CITY OF ALBUQUERQUE

**RE: Sonata Apartments, Phase II
Conceptual Grading Plans and Drainage Report
Engineer's Stamp Date: 10/25/22
Hydrology File: C10D001B**

RE Sonata Apartments, Phase II
Conceptual Grading and Drainage Plans and Drainage Report
Hydrology File: C10D001B

COA HYDROLOGY COMMENT RESPONSE

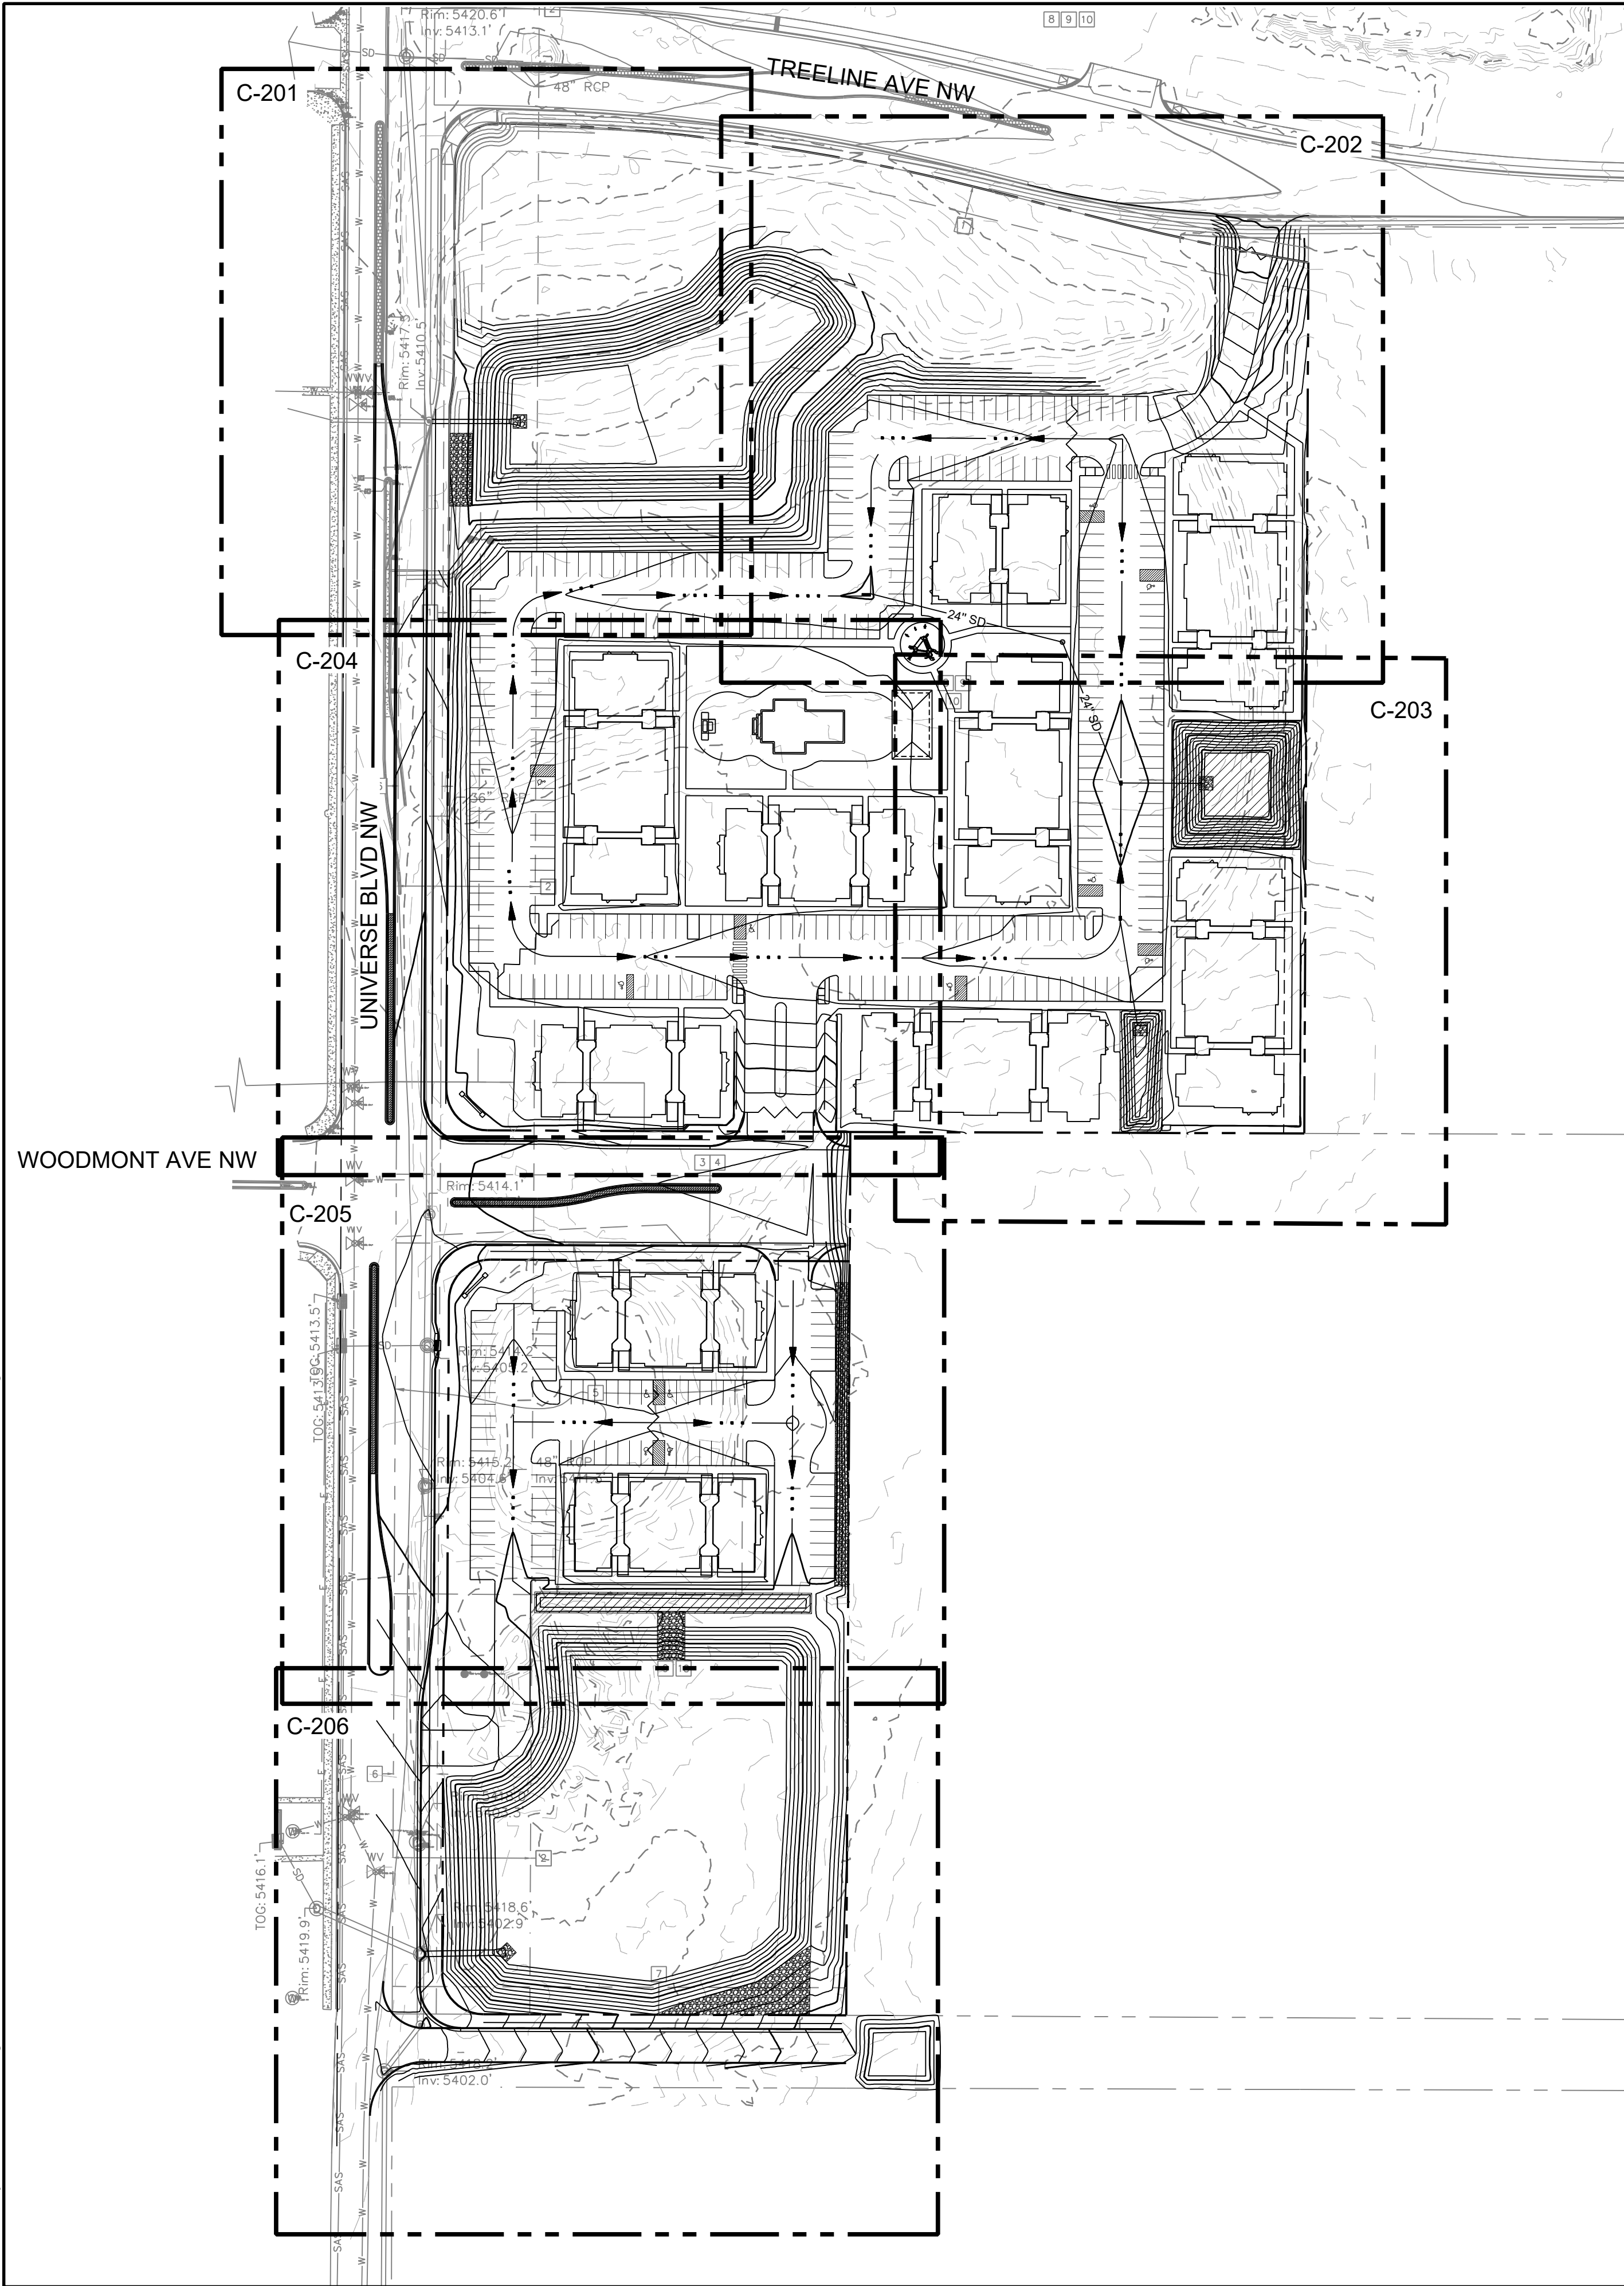
6. Sheet C-201 & C-202. Please show the grading that was done in Work Order (CPN 761284) within Treeline Ave R.O.W. [Revised.](#)

10. Sheet C-201. Please label the existing storm sewer and manhole as shown. Please make sure that any storm pipe over 30 -in is shown as a double line to the pipe's width. Also, the existing manhole is 6 - ft. Please reflect this in the drawing. [Revised.](#) There is three 48 -in pipes and a 30 -in pipe in the manhole. Please check to make sure that the manhole will be big enough for all of them. [Confirmed , all three pipes fit in the 6' diameter manhole .](#) Please shown an end section with some rip rap at the outfall into Pond L - 3. [Revised.](#)

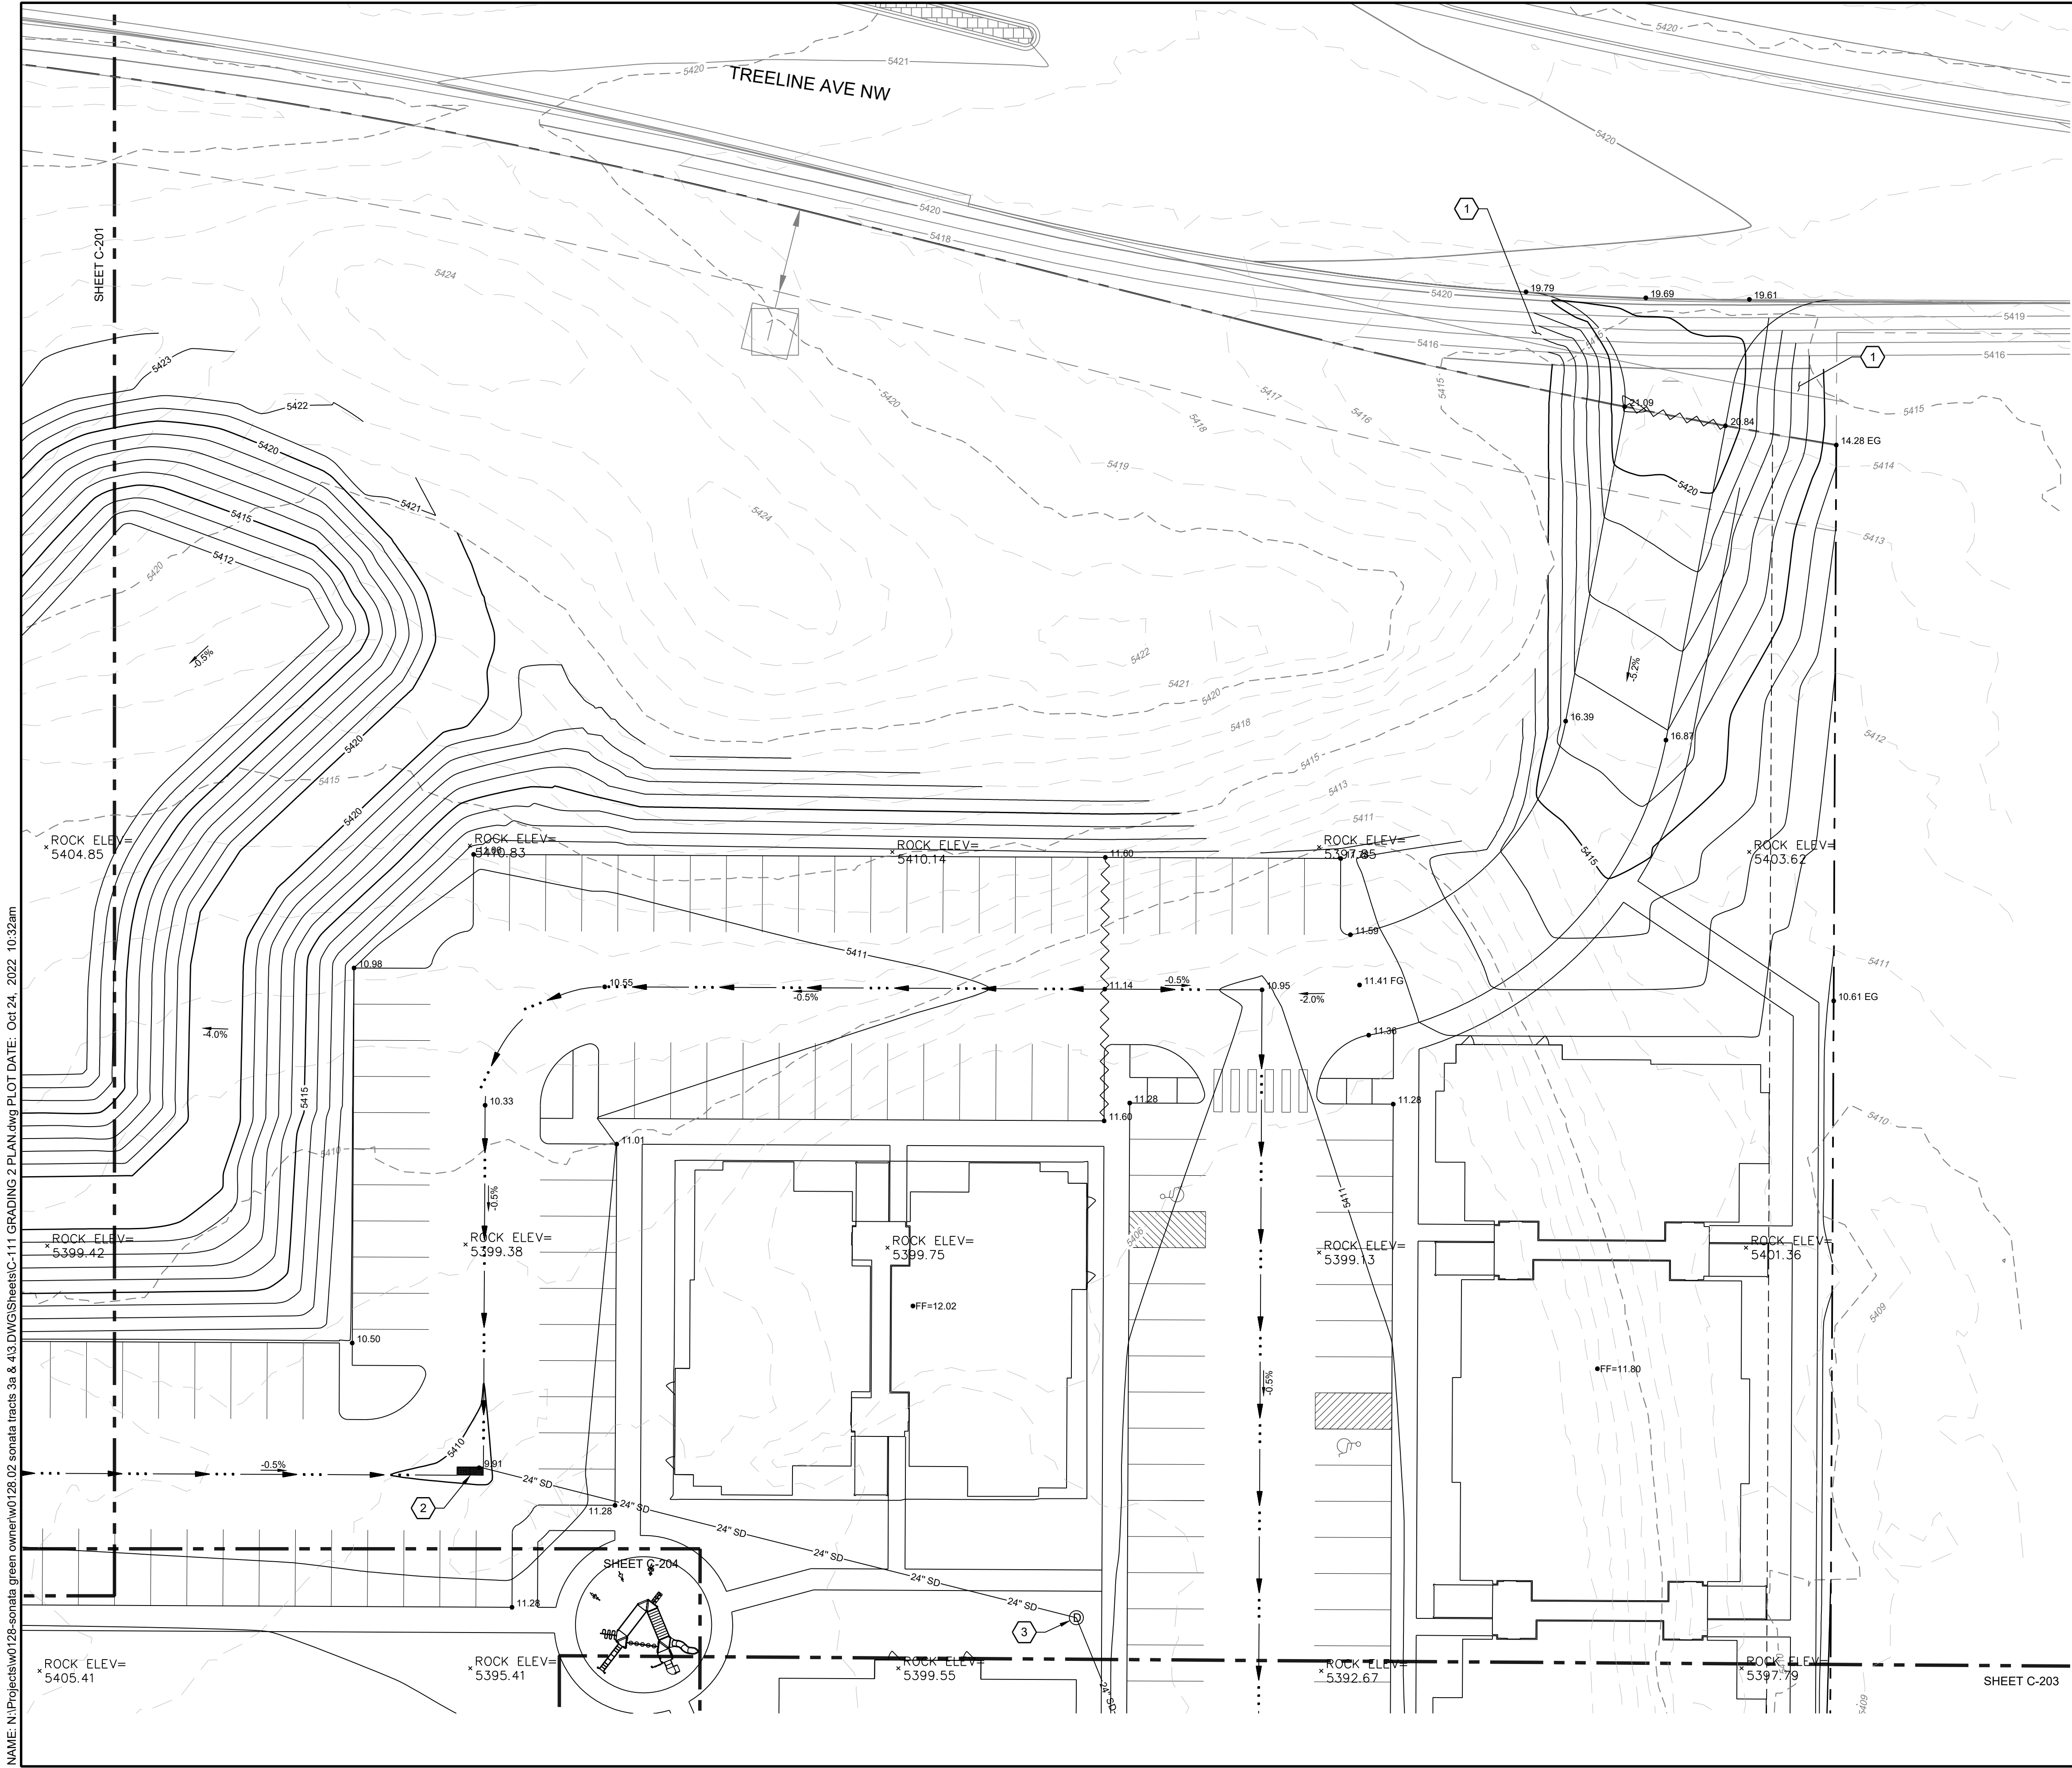
7. Sheet C-202. What is this hatch? If not needed, please remove. [Removed.](#)
